From: [Robert Eaton](#)
To: [Hemingway, James](#)
Cc: [M42 Junction 6; Nikki Bains](#); [Andrew Davies](#)
Subject: M42 Junction 6 Improvement Scheme, TR010027
Date: 08 October 2019 11:47:45
Attachments: [M42 J6 Birmingham Airport Statement of Common Ground DRAFT 270819.docx](#)
[DCO application - BHX relevant representation 26.3.19.pdf](#)

Further to the Issue Specific Hearing on Environmental Matters on 2 October, please find below our comments on the Outline Bird Strike Management Plan dated September 2019 together with other matters that remain outstanding.

Outline Bird Strike Management Plan

Figure M.2: Ecological Features and Airfield Safeguarding Areas Plan

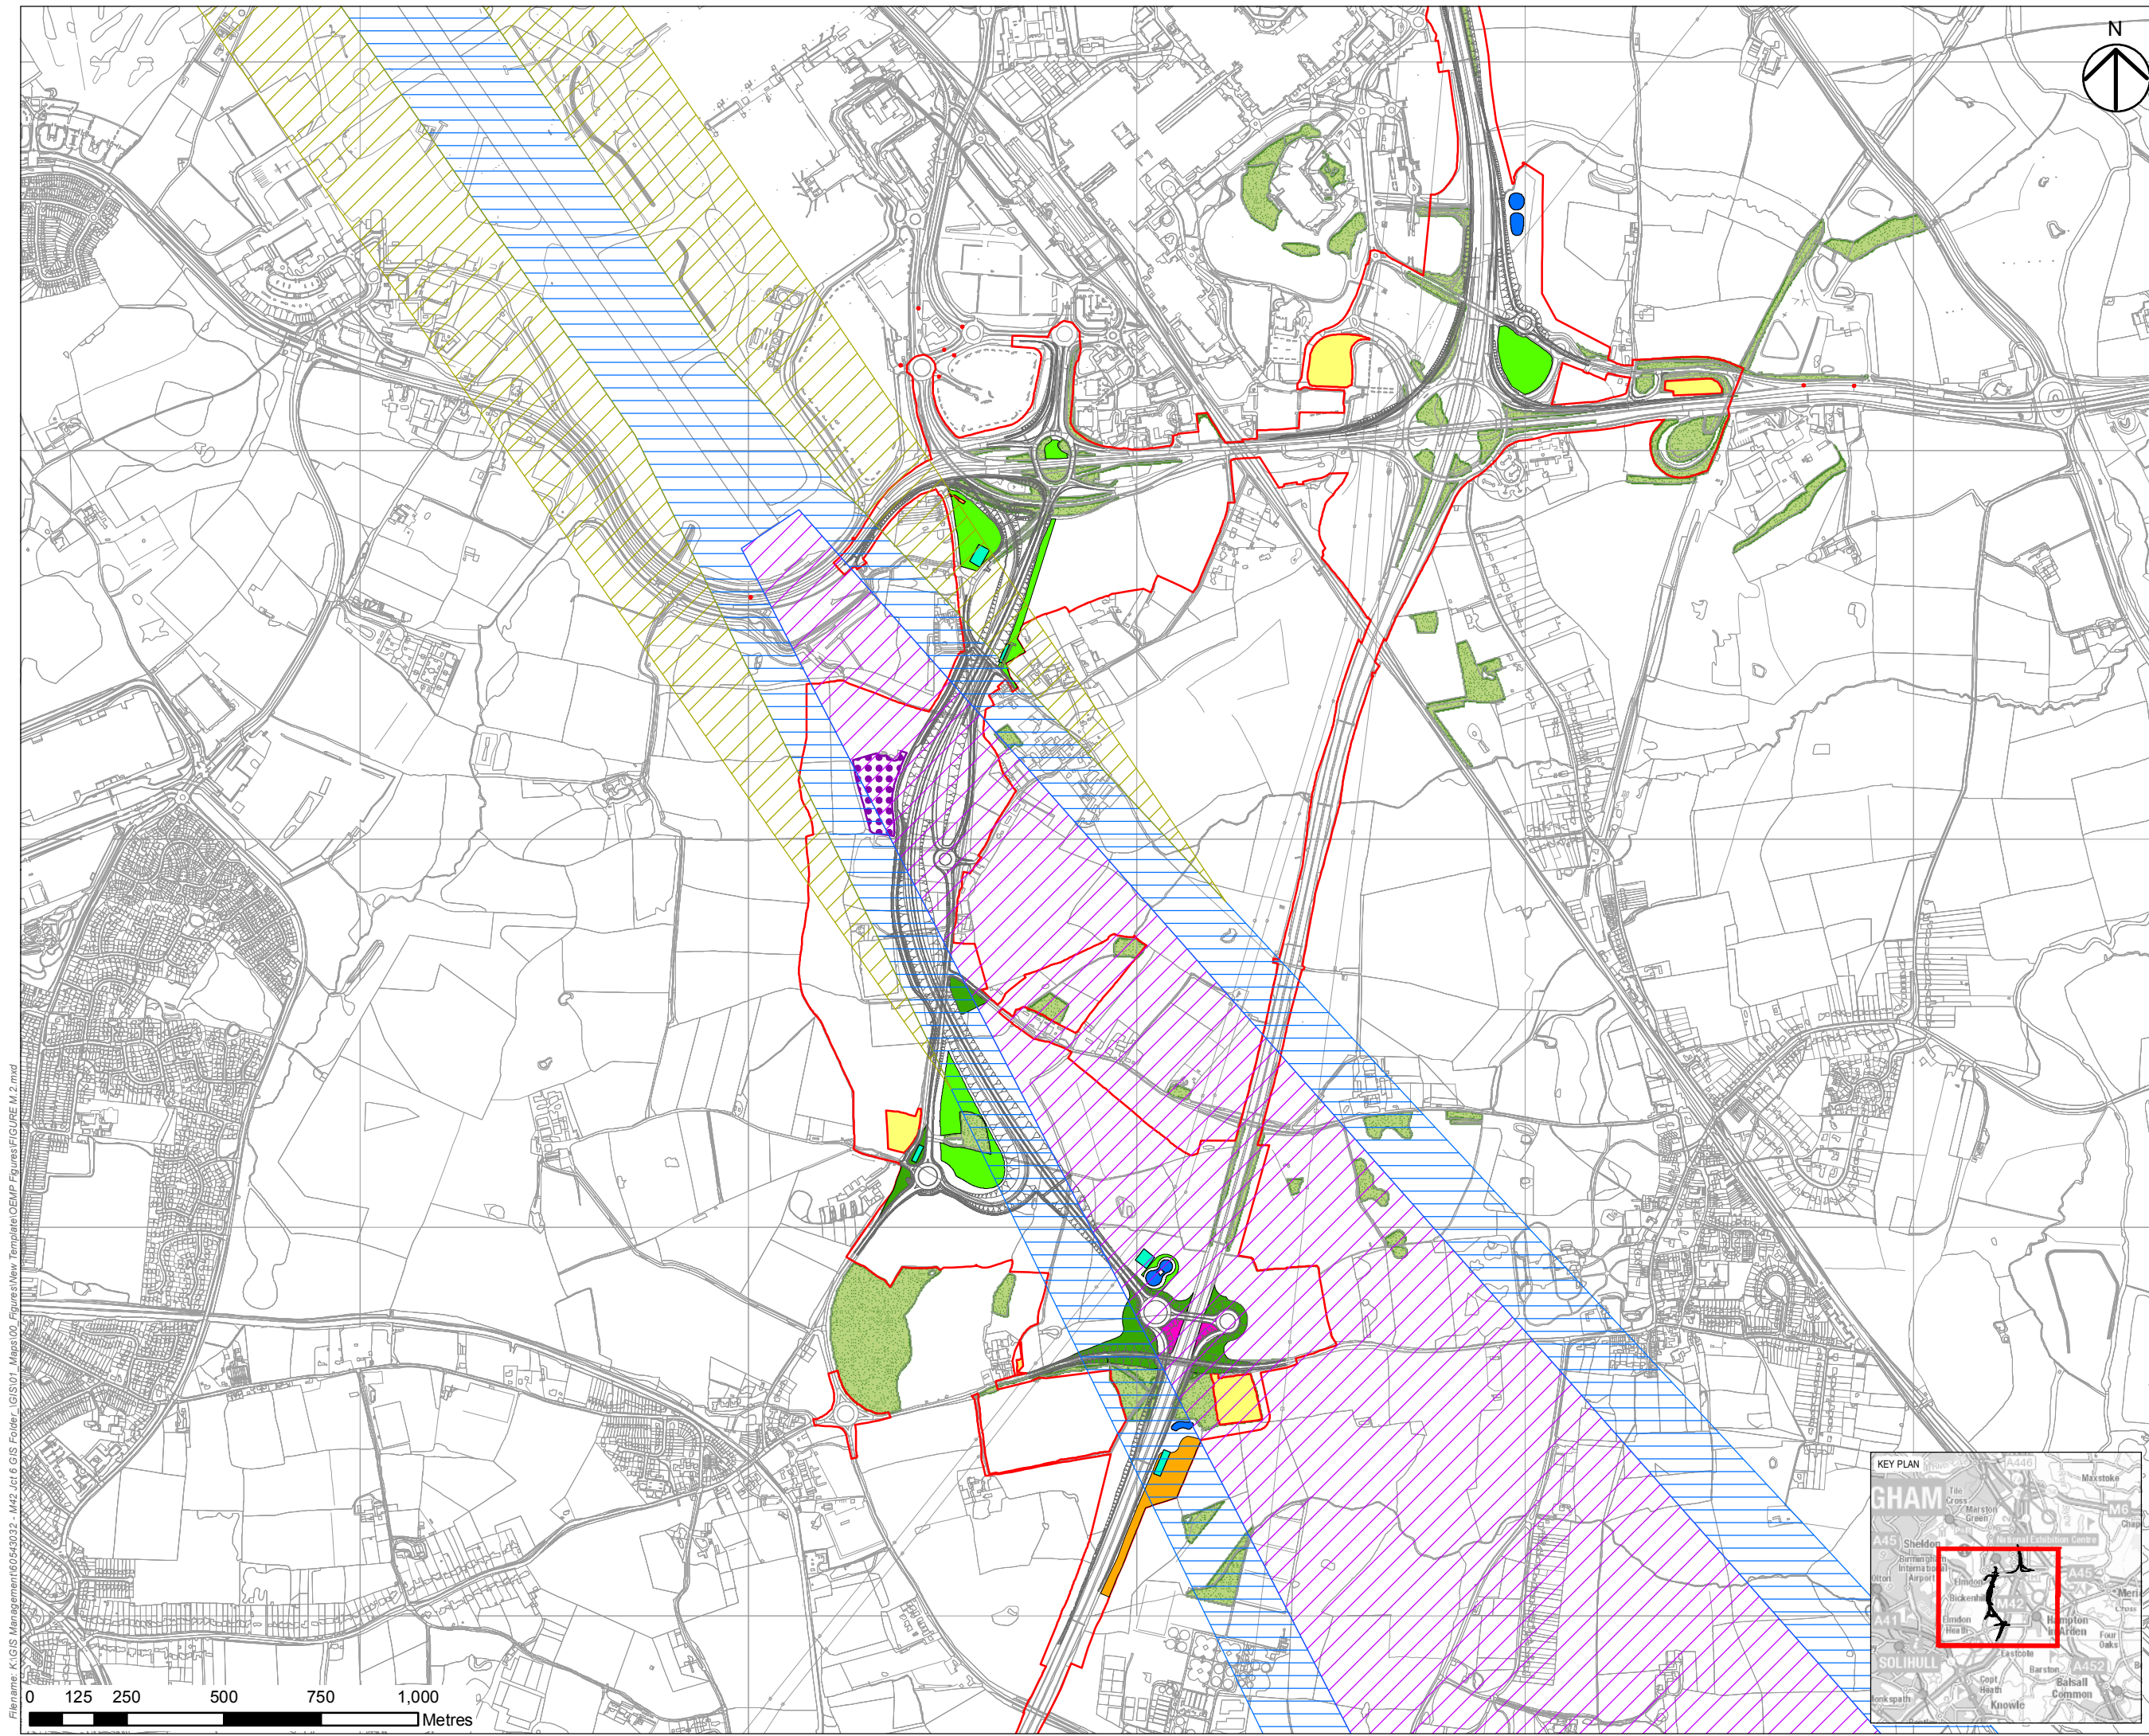
- Paragraph 4.4.5 states that "*Areas of the Scheme construction which are deemed to have a high potential of increasing the risk of bird strike to the airport ("high risk areas") will be agreed in consultation with Birmingham Airport Limited prior to the commencement of construction works.*" In reality, construction within the whole of the application site has a high potential of increasing the risk of Bird Strike as it all falls within the Airport safeguarding zone. This paragraph should therefore be amended to require the contractor to consult with the airport prior to any construction commencing and to continually monitor the effectiveness of the Management Plan throughout construction.
